January 17, 2014

Subject: Munjoy Heights
 Final Level III Site Plan – Conditions of Approval
 Comment Response Letter

On behalf of Redfern Munjoy, LLC we are pleased to address the conditions of approval that *pertain* to Acorn Engineering from the City of Portland, including:

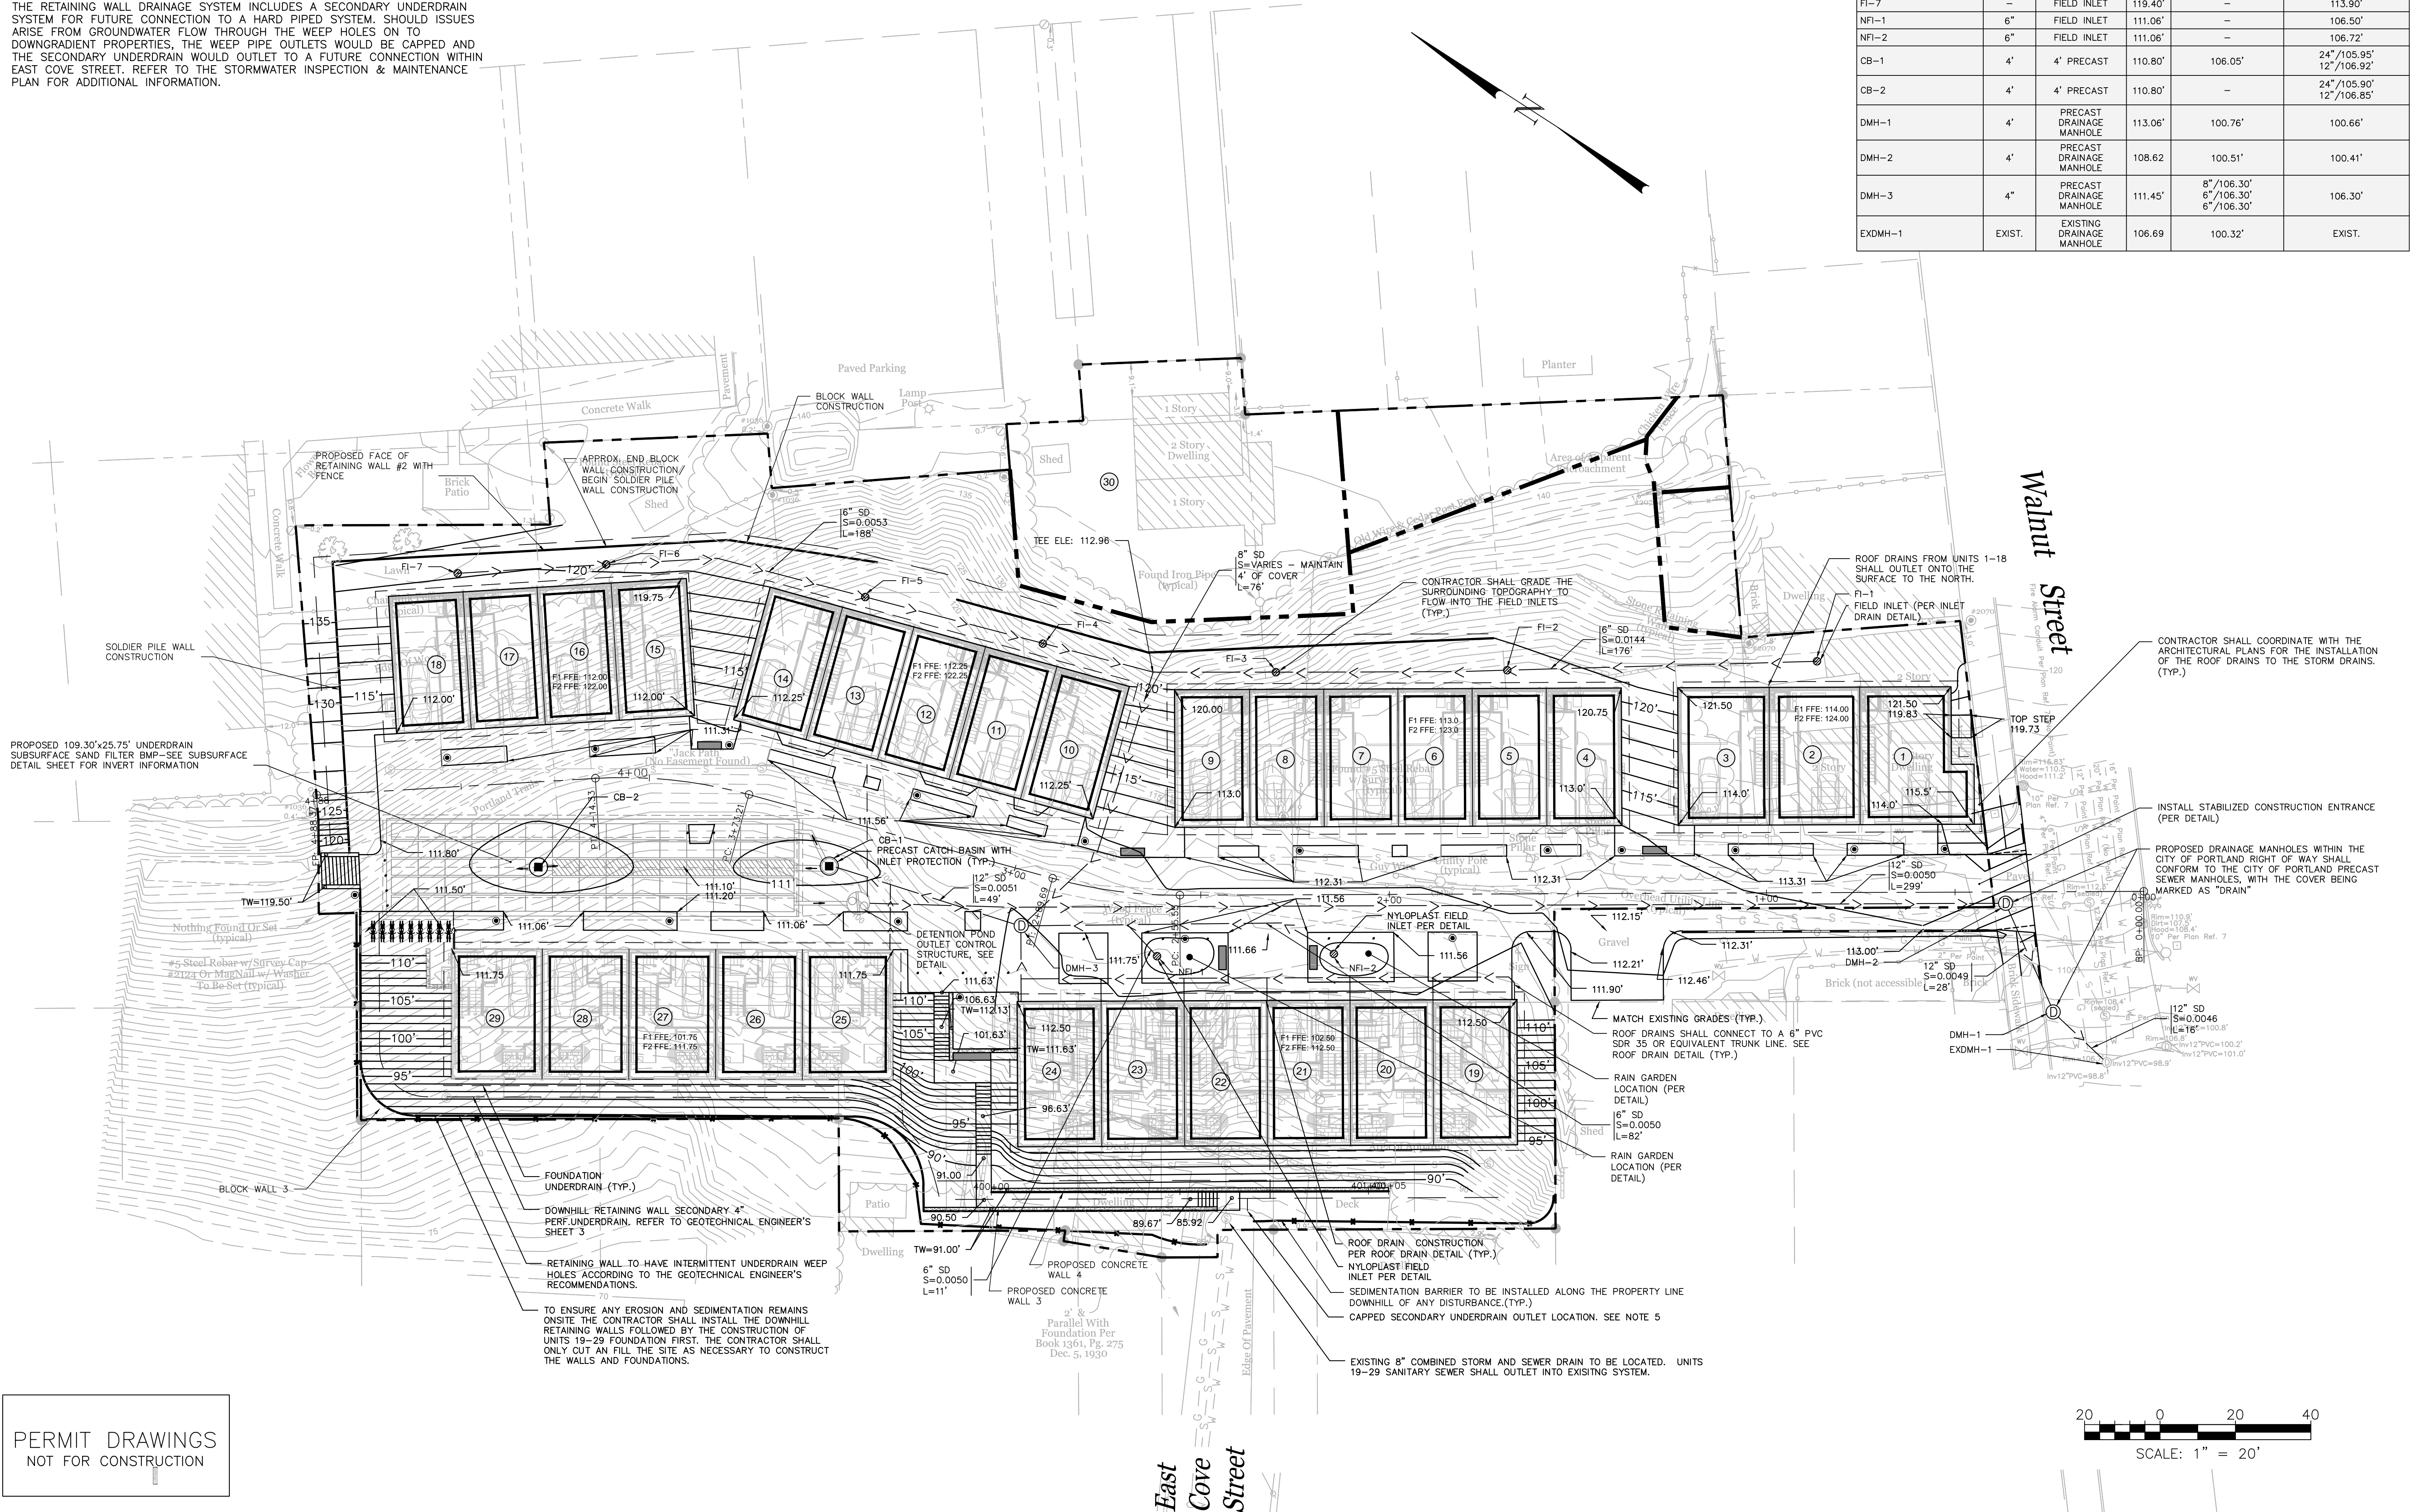
- 1) a), b) & c) (i.)(ii.)(iii.) – Comments adequately addressed.
- 2) a), b) & c) – Comments adequately addressed.
- d) Sheet C-30: The access/diversion structure labeled CB-1 has two outlets, a 12” pipe and a 24” pipe. The 24” pipe connects to the Isolator Row, whereas the 12” pipe appears to connect to an adjacent standard chamber. Please clarify the intent of 12” pipe, along with the invert elevation. Because the Isolator Row is intended to remove sediment and debris from the stormwater flow, we would not anticipate that the 12” pipe invert elevation would be set the same as the 24” pipe invert elevation. If the 12” pipe is acting as a high-flow outlet, we would anticipate that the invert elevation of this pipe would be set higher than the 24” pipe.

- 18) *The Applicant has noted that a revised C-30 drawing will be provided to address the previous review comment; we will review upon receiving the revised C-30 plan.*

19) *In general we agree with the Applicant's proposal to provide "weep holes" at the base of the wall in lieu of a direct connection to the combined sewer in East Cove Street. The Applicant should include details and notes on the plans for the weep hole outlets to ensure that they are properly stabilized and that they do not direct concentrated flow onto adjoining properties. Per discussions with City DPS, the Applicant should design the retaining wall drainage system and weep holes to allow for a future connection to a hard-piped system if issues arise from groundwater flow. Additional notes and design details should be submitted for review and approval.*

Response – The 12” pipe is acting as a high-flow outlet for CB 1 and CB 2. This has been clarified within the Drainage Control Structure Schedule on Sheet C-30.

Response – Sheet C-30 was revised to include sloped granite curb, along the driveway entrance, to redirect the stormwater away from the Rando property and towards the proposed rain gardens and USSF.

Acorn Engineering revised Sheet C-30 to include the following Note 5.

"5. The retaining wall drainage system includes a secondary underdrain system for future connection to a hard piped system. Should issues arise from groundwater flow through the weep holes on to downgradient properties, the weep pipe outlets would be capped and the secondary underdrain would outlet to a future connection within East Cove Street. Refer to the Stormwater Inspection & Maintenance Plan for additional information."

DRAWING NO. **C-42**

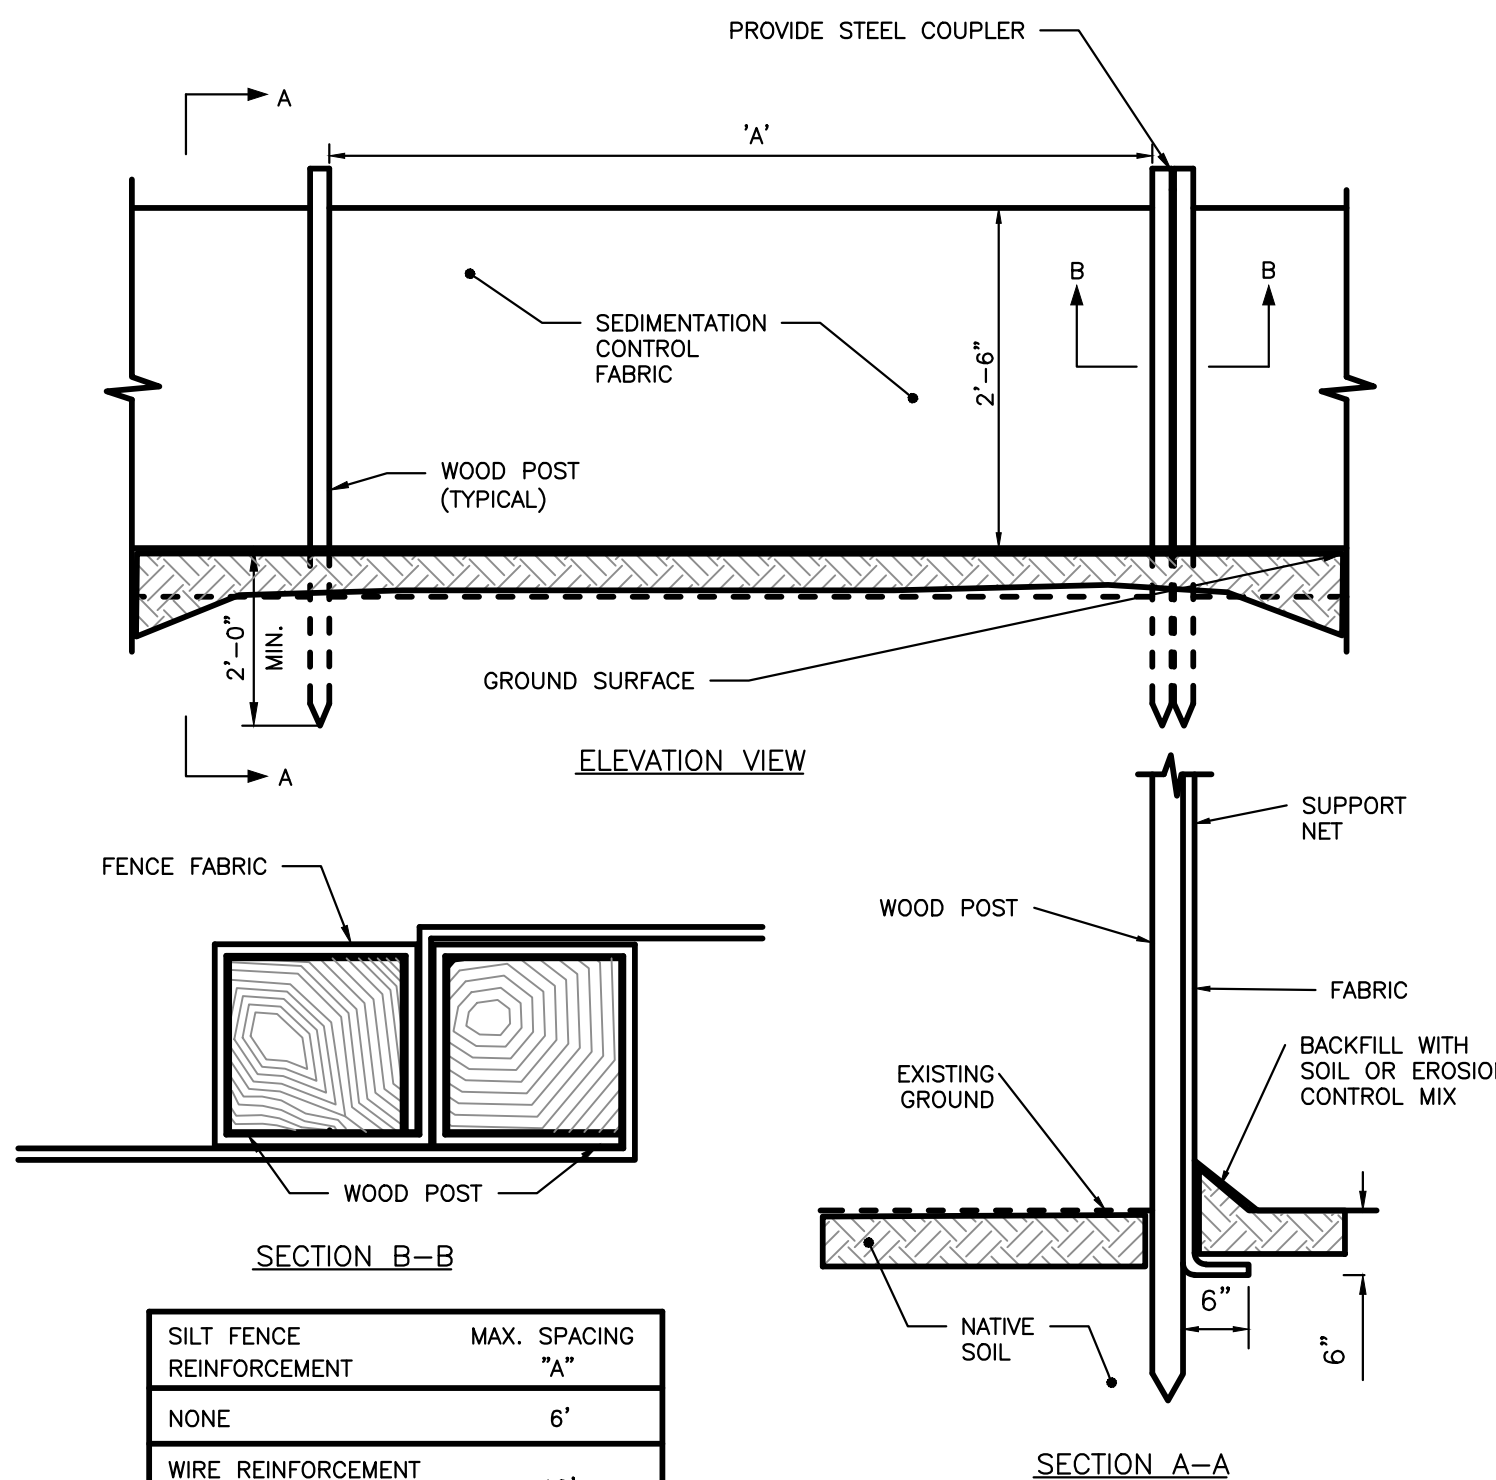
- 3) Comment adequately addressed relative to the Underdrained Subsurface Sand Filter. The plans contain additional details on two underdrained soil filters / rain gardens. It appears these systems were designed without an impermeable liner. We request review and comment on these systems by the project’s geotechnical engineer.

- 14) *Comment adequately addressed.*
 15) *Comment adequately addressed.*
 16) *Comment adequately addressed.*
 17) *The details provided for the underdrained soil filters (rain gardens) on C-42 do not provide sufficient detail at the edges of the system, where the in-slope meets the driveway/walkway pavers. The in-slope should be designed with measures to avoid erosion and under-mining of the adjacent pavers. As noted in Comment #3, the soil filters are not currently designed with an impermeable liner below the underdrain. The project geotechnical engineer should review the design to ensure that the introduction of surface water to the subsurface soils will not create geotechnical concerns.*

The email is included as an attachment. The Rain Garden Detail was revised to include an impermeable liner wrapping the bottom and sides extending to 6” above the channel protection volume. Refer to Sheet C-42.

Response – Additional edge information was provided for the Rain Garden Detail on Sheet C-42. The detail specifies concrete paver edge restraints, clarifies the size of the shoulder, and provides for river stones at points of concentrated flow to mitigate the potential for erosion and under-mining of the concrete pavers. Sideslopes not protected with river stone shall be stabilized with loam, seed and erosion control blanket.
